From: Laura Gibbons
Sent: 04 February 2019 12:32
To: Planning.Responses
Cc: Stuart Corbey
Subject: RE: Planning Consultation on EG/8/19/DOC

Engineers Comments Regarding Condition 3- surface water drainage

APPLICATION **EG/8/19/DOC**

Registered: 22-JAN-19
Site Address: Trebarwith Cottage Barnham Road Eastergate PO20 3RS
Description of Works: Approval of details reserved by condition imposed under ref EG/67/18/HH relating to Condition No 3 surface water drainage.

SITE PLAN SCALE 1:200

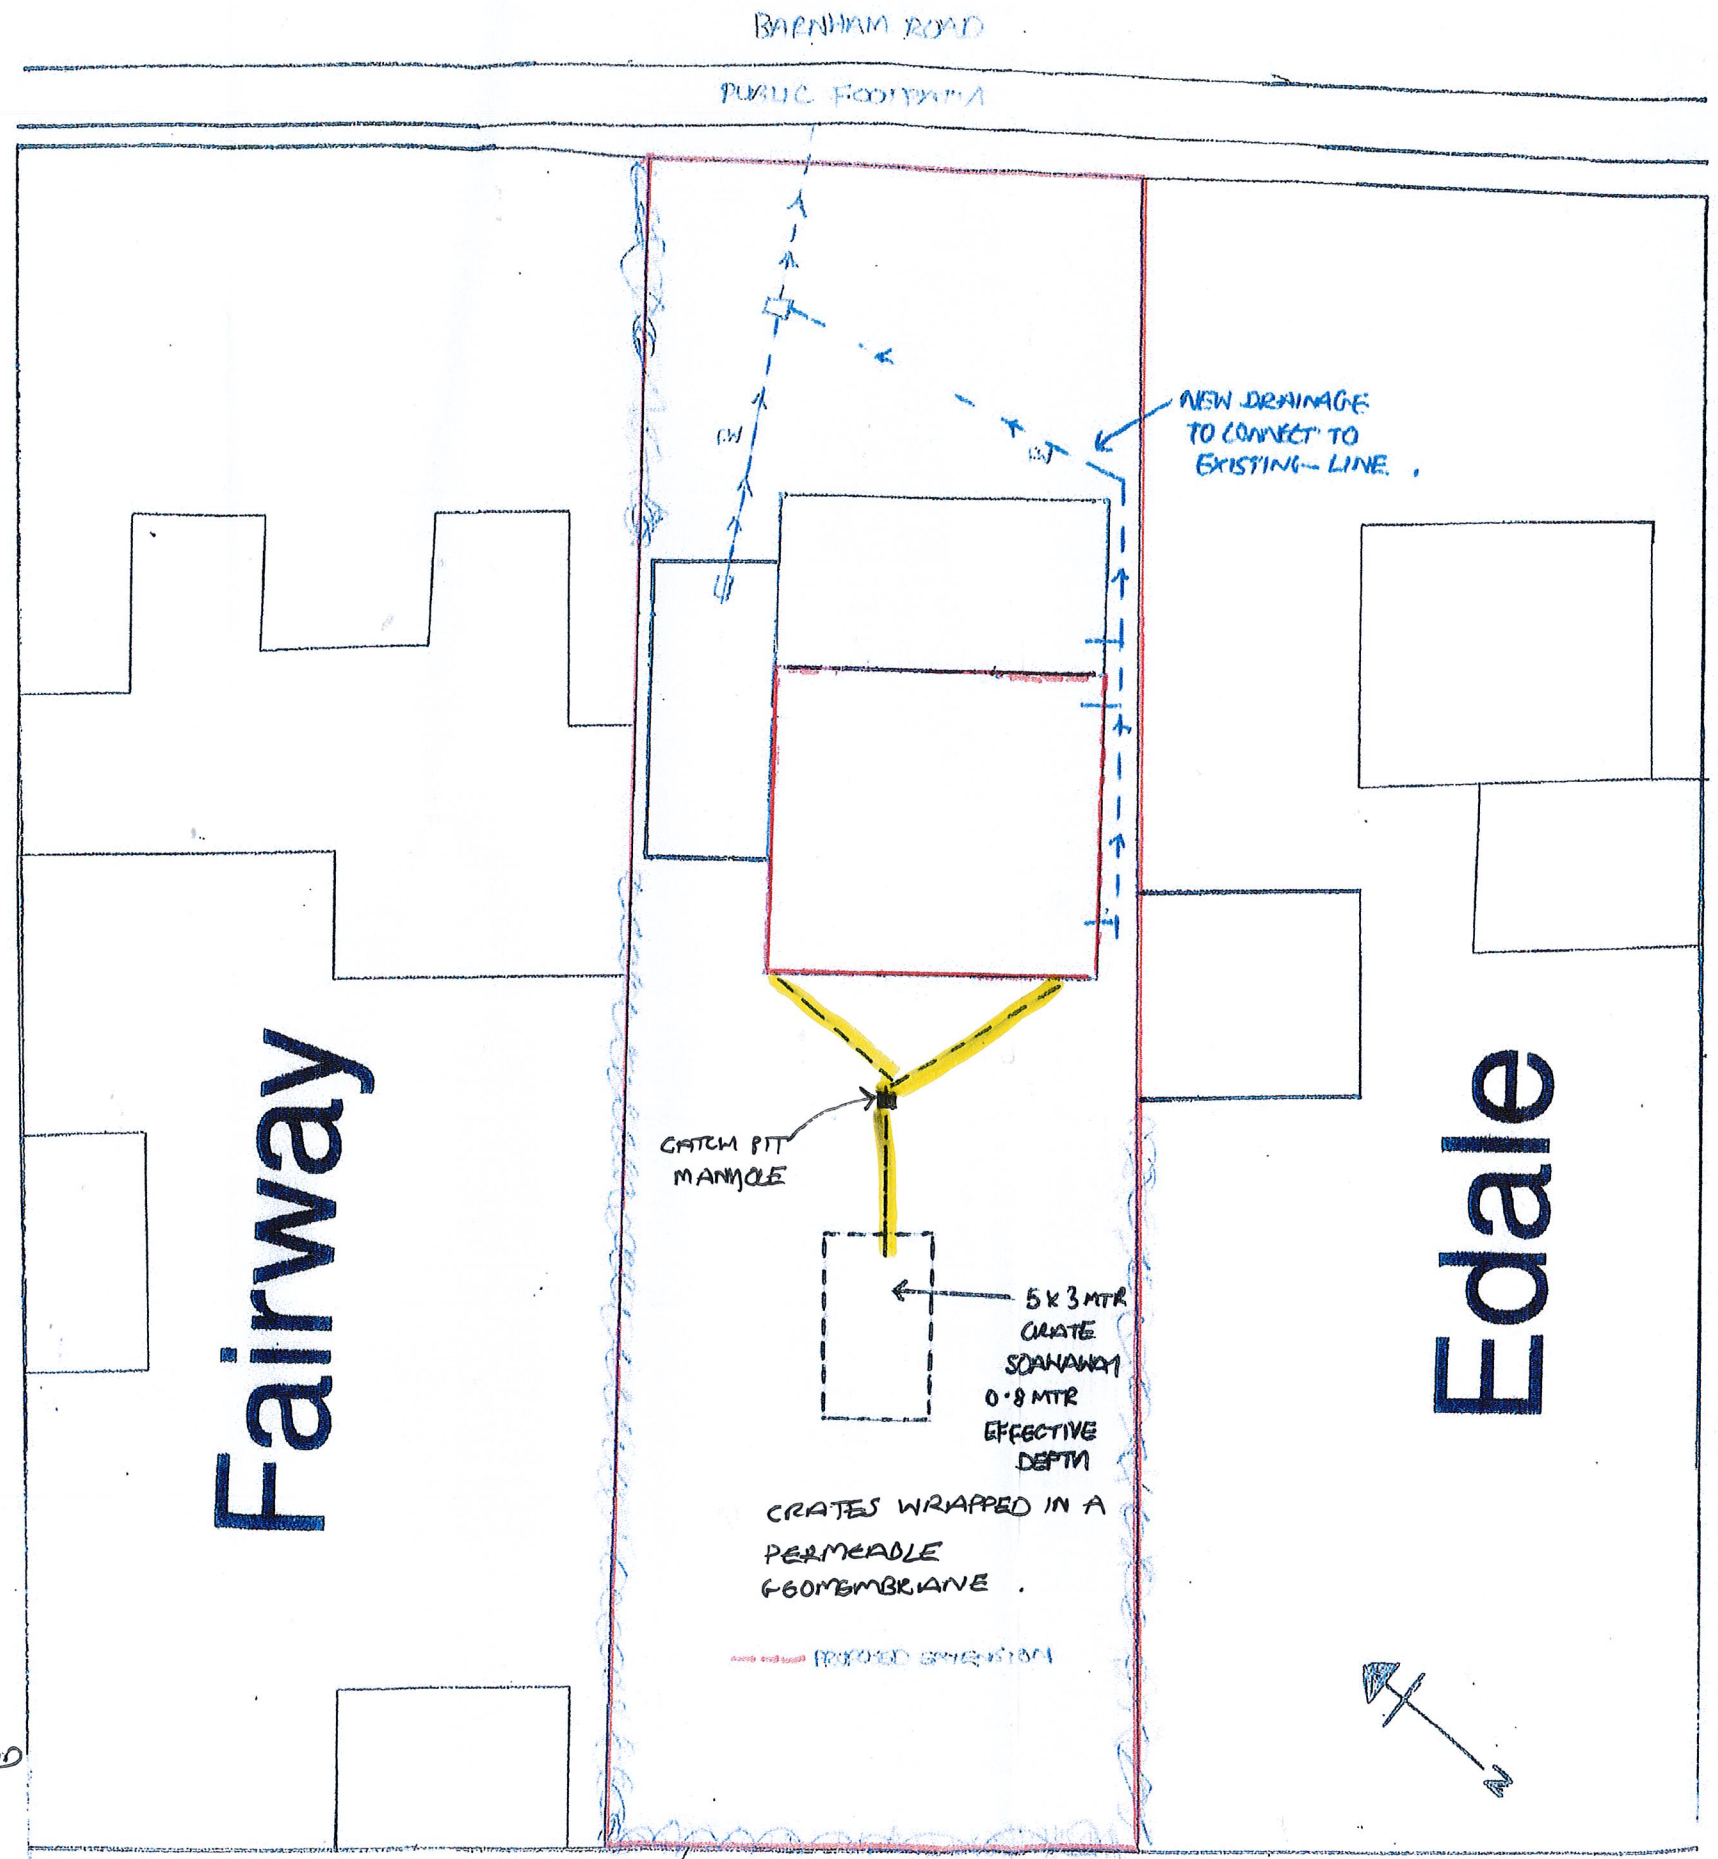
I have previously had discussions with the applicant regarding this application. Groundwater monitoring was completed in early January, groundwater was not encountered above 1.5m depth. The soakaway has been sized based on the worst recorded infiltration rate. Other alterations have been made to the design to take on board my earlier concerns.

I recommend the condition is discharged based on the information supplied.
